From: Andrew Wood
Sent: 20 June 2017 16:51
To: Juan Baeza
Subject: RE: FG 198/16/PL - VERY URGENT

From: [REDACTED]
Sent: 20 June 2017 12:25
To: Andrew Wood
Cc: carole robertson; Cllr. Roger Elkins
Subject: Fwd: FG 198/16/PL - VERY URGENT

1. **Height of the proposed block of flats** - p 32 of the DCC agenda states that “the development would have a 6.4m maximum height on the front elevation on Sea Drive”. Andrew Woods stated in an email to my neighbour’s son, Jon Gann on 25/4/17 at 10.42, “The substitute elevation plan ‘proposed elevation and street scenes’ drawing no 16/046 PL005 Rev F dated March 2017....does indicate that the height of the building above the car park entrance has risen by 30cm from 6.3metres to 6.6metres.” This email was pasted into my formal complaint text. Should you be in any doubt i can forward it to you again.

STREET SCENE SEA DRIVE

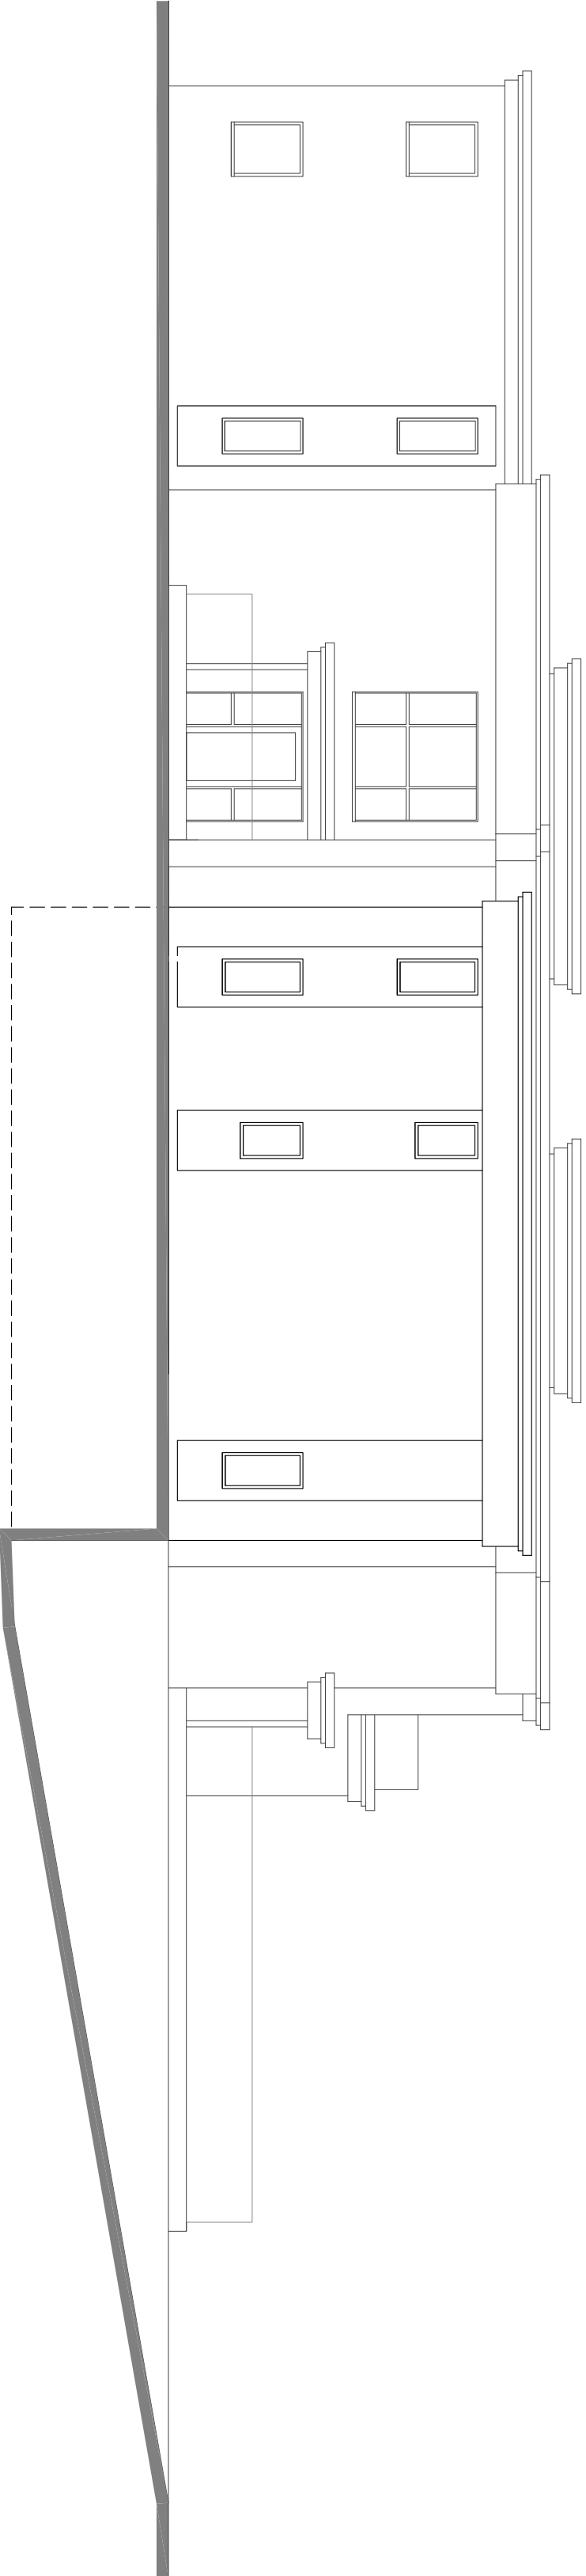
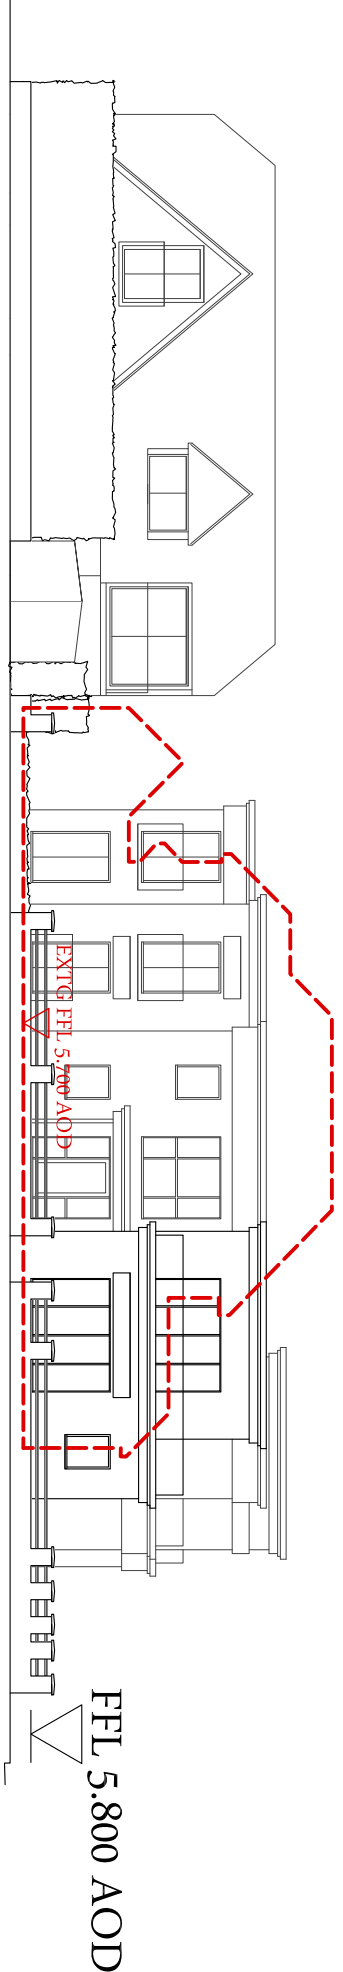
1. We know the proposal is "NO LOWER THAN 5.8m AOD" as per the drawings, and your proposed condition 10, what we are concerned about is how high it will actually be as substantial overlooking already occurs from ground floor level at 5.8m AOD.

3. Please confirm that you have amended the report to highlight that the windows of this proposal would be higher than our adjacent property and that there would be overlooking into our habitable room windows.

What height is it ? Which statement is correct ? This is a hugely important factor in assessing the overbearing impact of the proposal and it simply is totally unacceptable to have these inconsistencies.

2. **Level of Windows** - p.33 states that “the level of the windows shown on street elevations matches that of 3 Sea Drive and would provide an acceptable relationship between the windows and floor levels of the neighbouring property”. It is very clearly shown on the applicant’s most recent street scene drawing 16/046 PL005 Revision G that the level of windows on the proposed flat block are significantly higher than those in our property. The finished floor level is shown as 5.8m AOD, this fact in itself makes it very clear that the windows will of course be correspondingly higher and the drawings confirm that indeed they are.

The height of the proposed block has raised 20 cm from the plans first submitted as shown on PL005 Rev F due to the inclusion of the underground car park. The minor error (10cm) occurred in the response to Mr. Gann was due to line thickness on the plans.

The windows do generally match the height of some of the windows in your property, particularly those on the western side of the front elevation in your property when viewed from Sea Drive. None of the front windows on your property would be overlooked. As stated in the report it is not considered that the overlooking toward your property is significant nor contrary to planning policy. The only windows, other than fixed shut obscure glazed windows, which would face your property, are at the rear and at a distance of more than 20 metres from your primary habitable room windows.
